**TENDER CARE VETERINARY CENTER**

**SITE GRADING EROSION CONTROL PLAN**

SHEET: C1

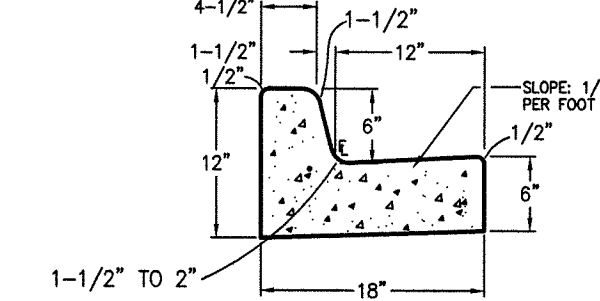
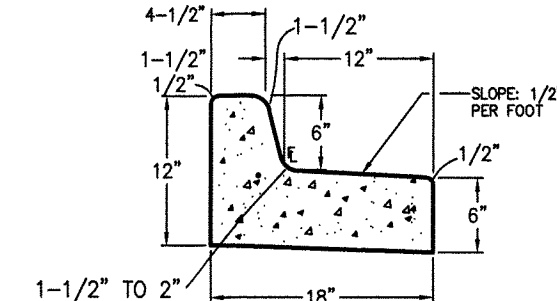
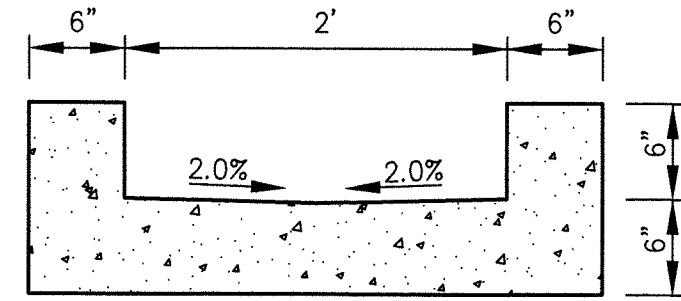
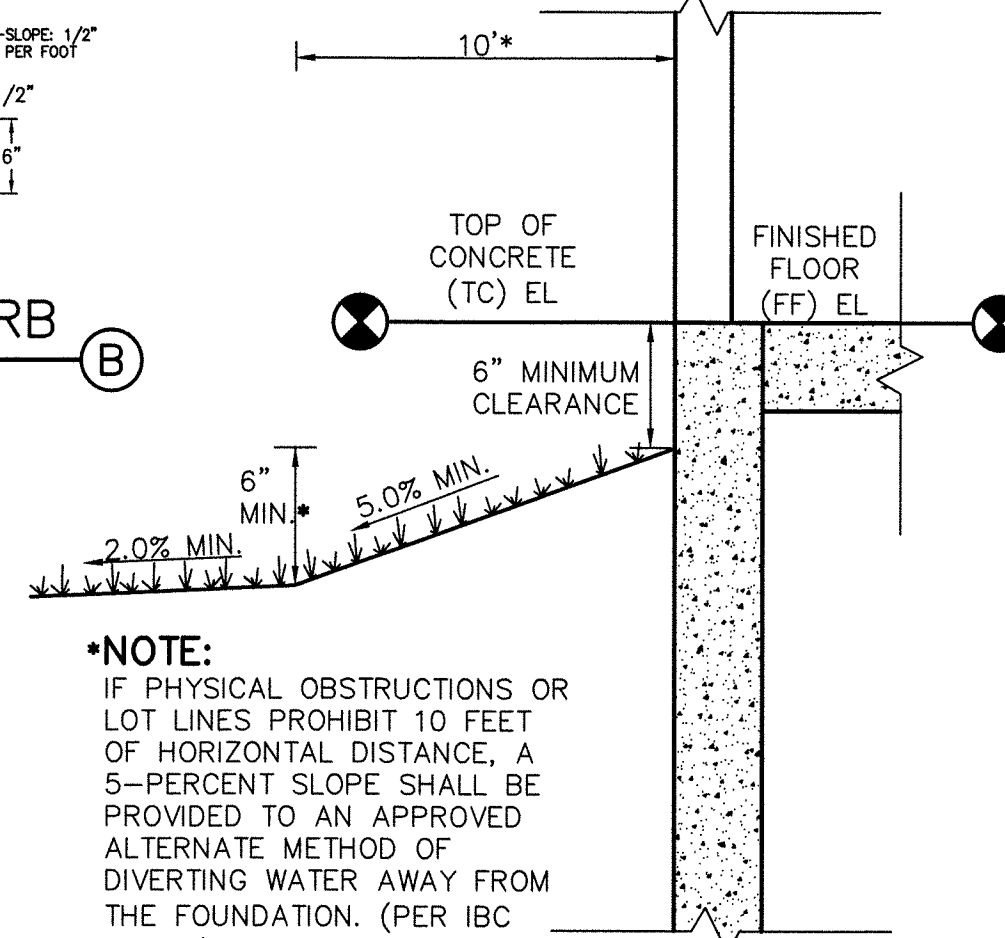
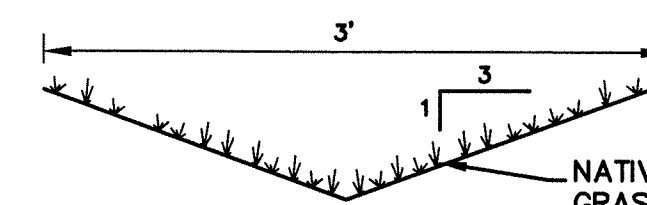
All sediment must be contained on site. Recommend installing inlet protection for any downstream inlets.

Remove this signature block.
